# LSC Responses to Town Comments

16050 Old Denver Road Rezone (LSC #S234320)

Figure 3b

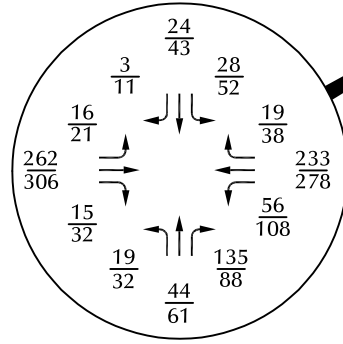
[is this callout correct? based on Town criteria, ~350 should be the prescribed stopping distance, pointing to the black line. interpolating for 45mph @ 3% upgrade.](#)

[is this callout correct? based on Town criteria, ~350 should be the prescribed stopping distance, pointing to the black line. interpolating for 45mph @ 3% upgrade.](#)

LSC Response: The prescribed stopping sight distance of 360' is per AASHTO Table 3-1 as the Town stopping sight distance Table 5-5 does not list criteria for 45 mph. Note: To be conservative at this stage of the process, the criteria for level terrain was used instead of the criteria with adjustment for an upgrade. This is because a detailed roadway centerline profile is not available.

LSC Response: The prescribed stopping sight distance of 360' is per AASHTO Table 3-1 as Table 5-5 does not have a criteria for 45 mph. The label has been corrected to reflect use of AASHTO table 3-1.

Figure 4

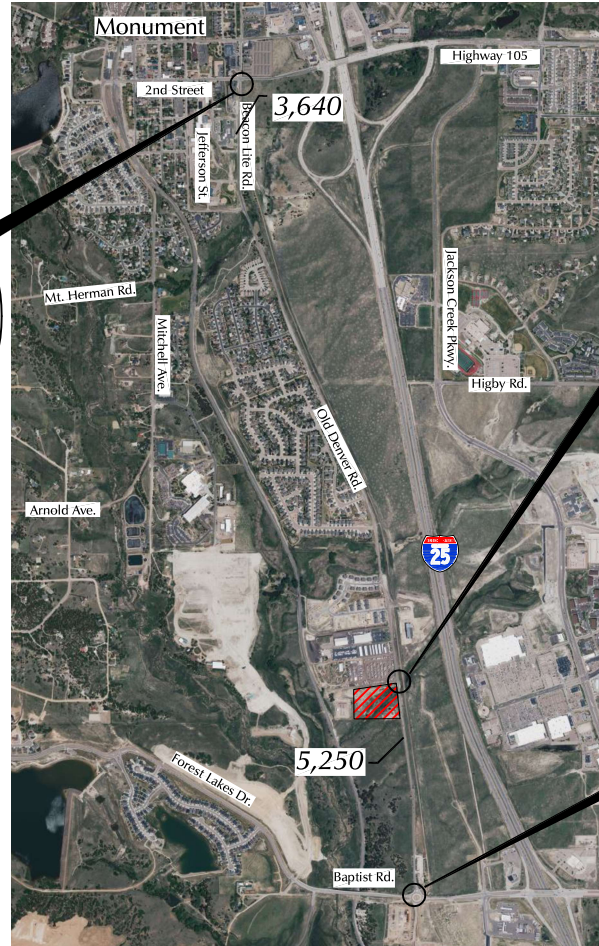
Number: 1 Author: M HEUGH Subject: Callout Date: 1/30/2024 12:19:55 PM  
[text says southern access.](#) [this looks like northern access.](#) [please adjust.](#)

Author: kdfer Subject: Sticky Note Date: 2/15/2024 2:11:58 PM  
LSC Response: Revised to show the count location at the south access.
